GATWICK AIRPORT NORTHERN RUNWAY PROJECT

Planning Inspectorate's Reference: TR020005

Comments on The Applicant's Response To The ExA's Written Questions (ExQ1)

DEADLINE 4: 15 May 2024

Permanent Diversion of 346_2Sy

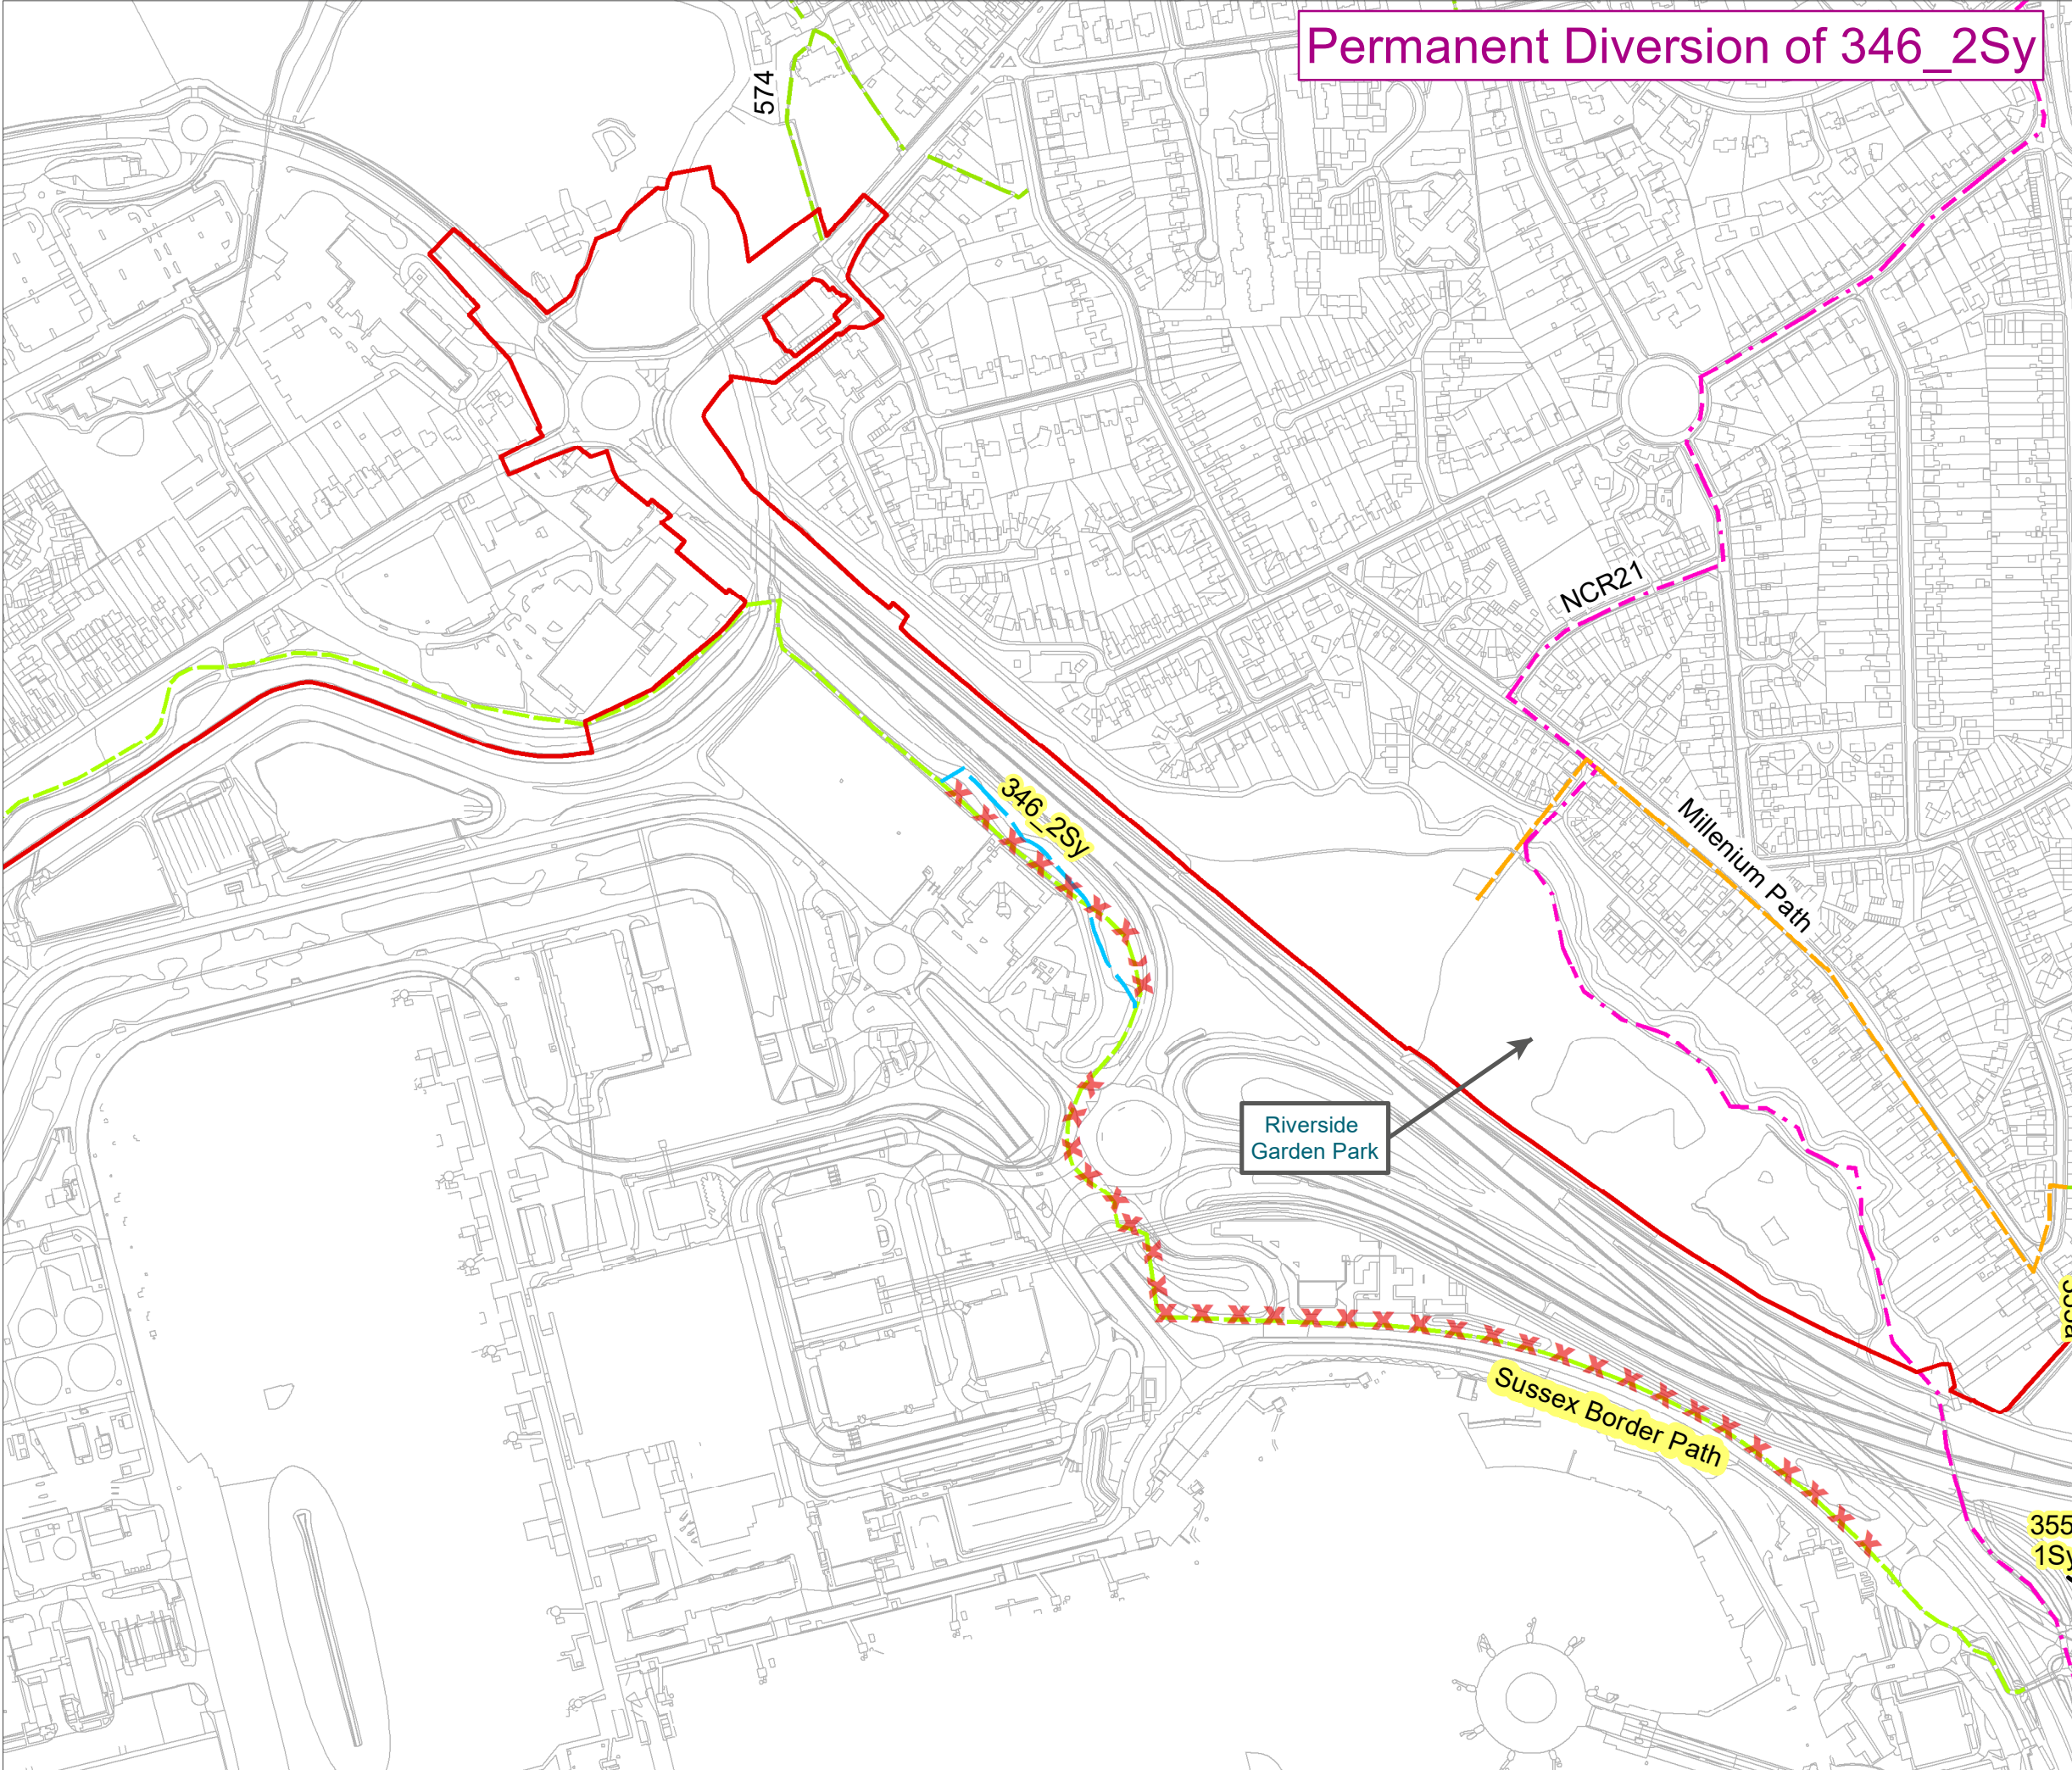
ExQ1	Question to:	Question and Applicant's Answer	Legal Partnership Response
		<p>established pedestrian routes on the site. Should this form part of the PRow diversion within the dDCO?</p> <p>The relevant section of Public Right of Way Footpath 346_2sy is labelled as B2 on Sheet 1 of the Rights of Way and Access Plans [REP1-014]. This section of footpath is currently coincident with various Rights of Way with a highway designation (including Longbridge Way, North Terminal Roundabout, Gatwick Way and Perimeter Road North and the associated footways which form part of the highway). To address this existing issue of overlapping Rights of Way, the footpath is to be stopped up where it is coincident with highways (as is the case elsewhere along the footpaths associated with Sussex Border Path). The Sussex Border Path long distance trail would follow the proposed predominantly shared use path provision that reflects a rationalised version of the current route as stated in Table 4.1.1 of ES Appendix 19.8.1: Public Rights of Way Management Strategy [REP2-009]. The relevant labelled sections of the replacement route on Sheet 1 of the Rights of Way and Access Plans are as follows: c11 (southwestern section), c8 (eastern section), c40, c6, c5, c4, c3 and c2. Waymarking signage would be updated to reflect the revised Sussex Border Path trail route.</p>
